**From:** Jeff Rice  
**Sent:** Monday, November 30, 2020 3:34 PM  
**To:** Judith Espinoza  
**Cc:** Elizabeth Nijkamp; Craig Dossey  
**Subject:** RE: 18755 Rockbrook Review

The BDA plan set (R137005) has been resubmitted and is back into our queue for the above referenced subject location, 18755 Rockbrook Rd.

Plat 14293 note 15 states the following:

✓ SITE PLAN  
 18755 ROCKBROOK ROAD  
 BAXTER RESIDENCE  
 LOT 1, YARBROUGH SUB.

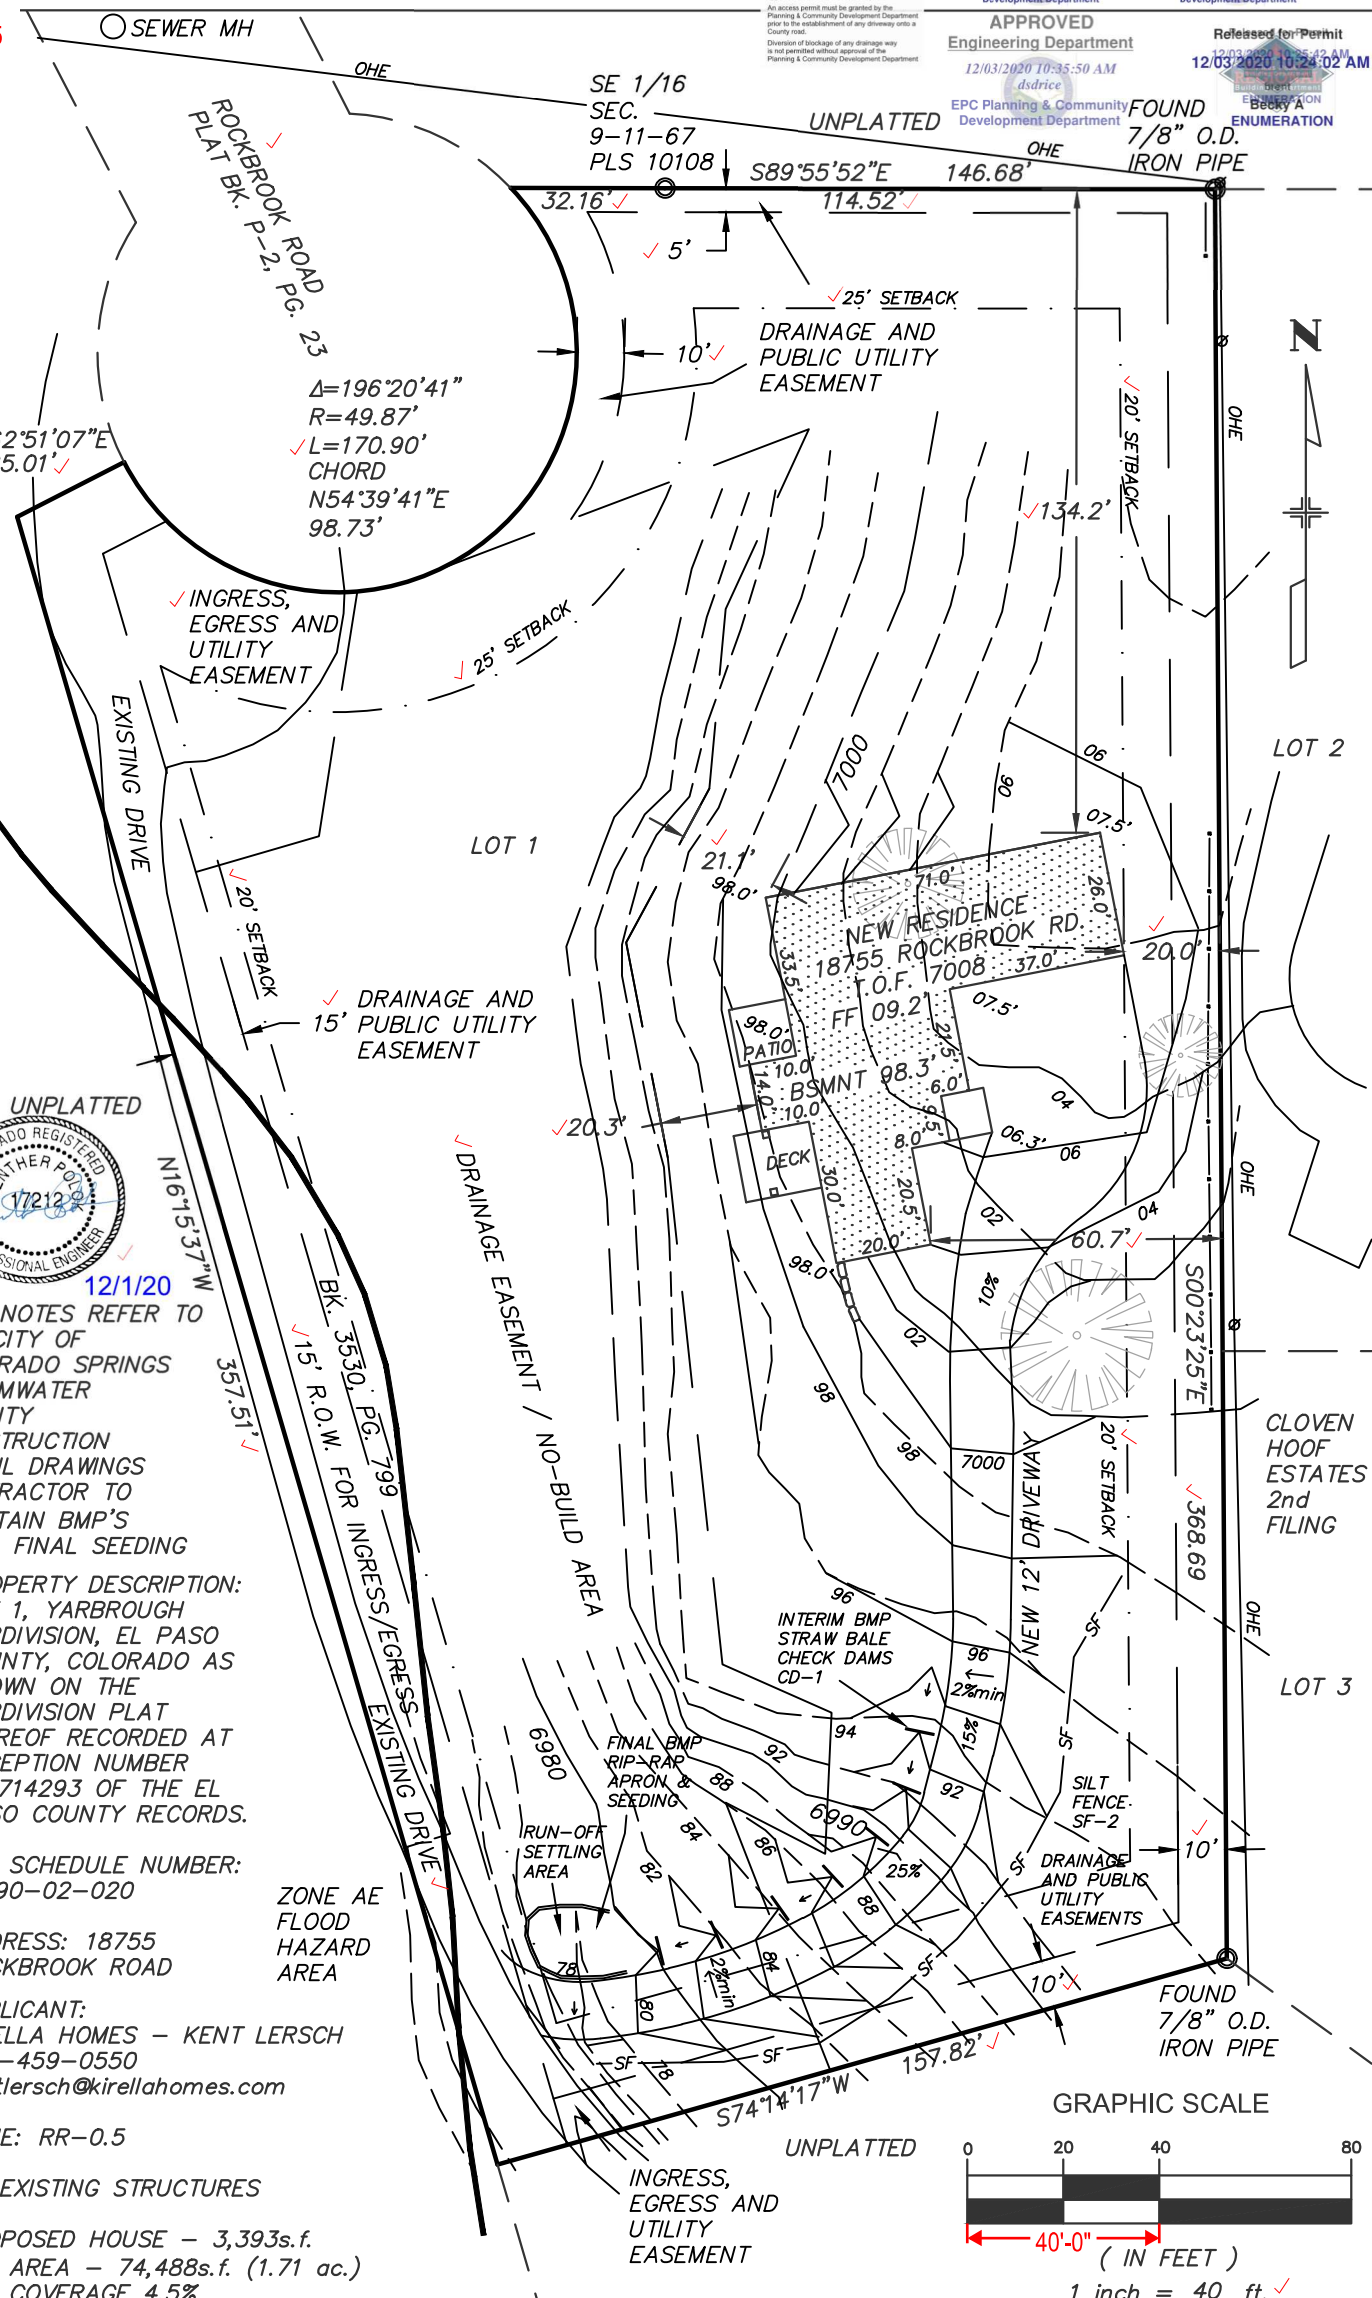
An engineered site plan requires complete grading and drainage details for the site. In this case the main concern is drainage runoff coming down the proposed driveway, which will require a significant amount of grading due to the steep grade. A “ditch-out” or settling area for runoff from the driveway should be provided to minimize the potential for downstream erosion impacts. In order to complete and approve the engineering review we need a grading plan showing existing and proposed contours for the driveway and home construction and the settling area or ditch proposed to control the runoff at a non-erosive velocity. The grading plan needs to be signed and stamped by a professional engineer.

The resubmitted plot plan was designed by a land surveying company (LWA Land Surveying, Inc) and not engineering stamped. However, the applicant has submitted an engineer site plan review letter (stamped) from an engineering firm, Mibar Engineering LTD regarding their review of the submitted site plan. Will this satisfy requirements for plat note 15? If so, will you please forward this plan set to one of your staff engineers for review approval and/or comment(s), and I will continue my review for approval. Jeff is a bit familiar with this one.

Craig got me an answer (we can't override the plat note) so I'll give Kent a call and let him know.

I apologize for the confusion – as you can guess we don't have a lot of plats with this plat note. If there is a way we can track approval of the grading plan prior to approval of the CO I would be okay with that but we would need to coordinate with PPRBD on that and I don't think it meets the requirements of the plat note. We will need to verify with our Director that we can do this.
